Application for a Non-Material Amendment Following a Grant of Planning Permission

Two storey side extension following demolition of garage and utility.

SDNP/22/01905/HOUS

Amendment to change the roof windows on the left elevation to sun tunnels

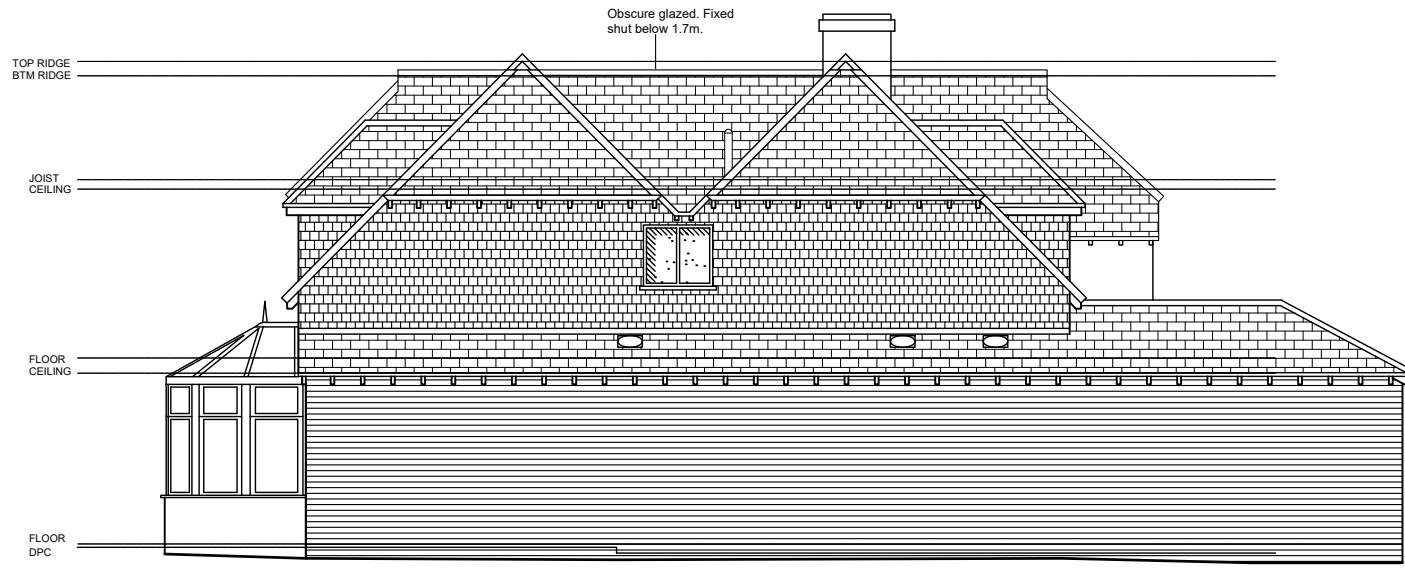
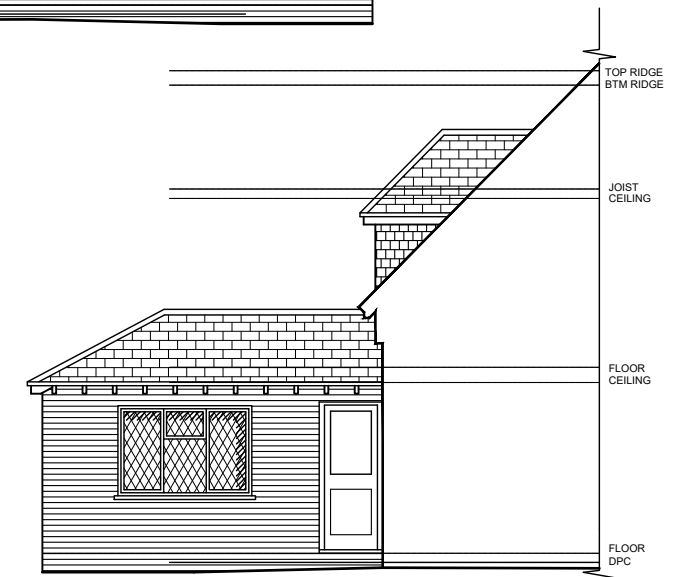
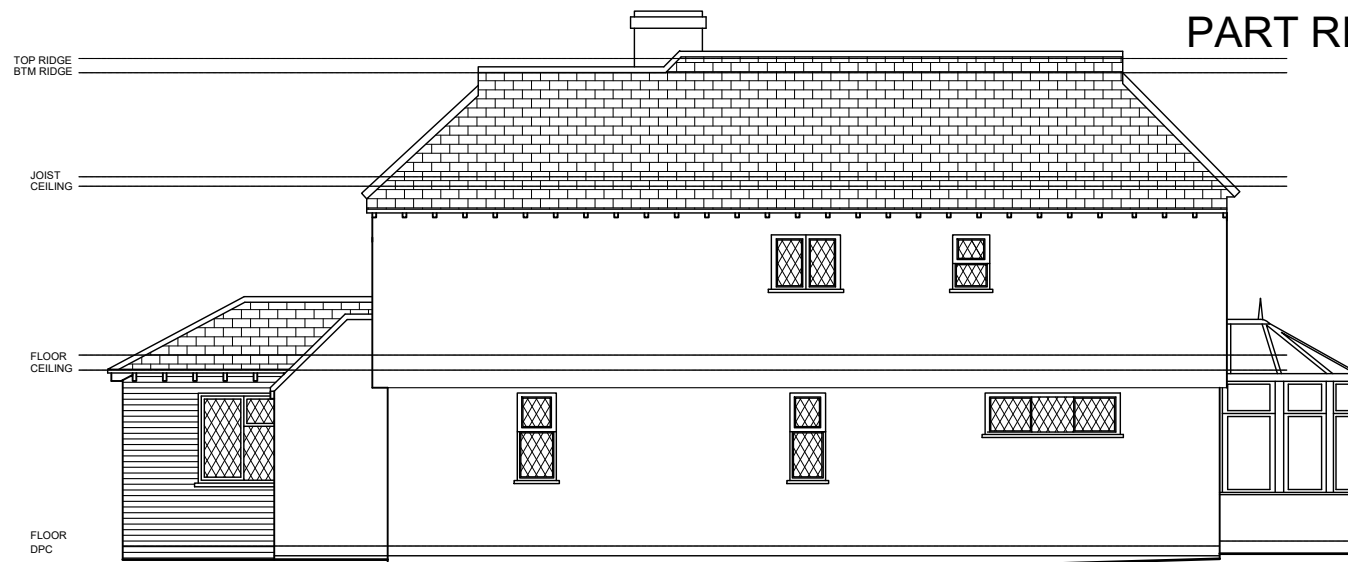
There wasn't enough space to fit in roof windows.

11/125-003 REV D
11/125-004 REV D
11/125-007 REV C
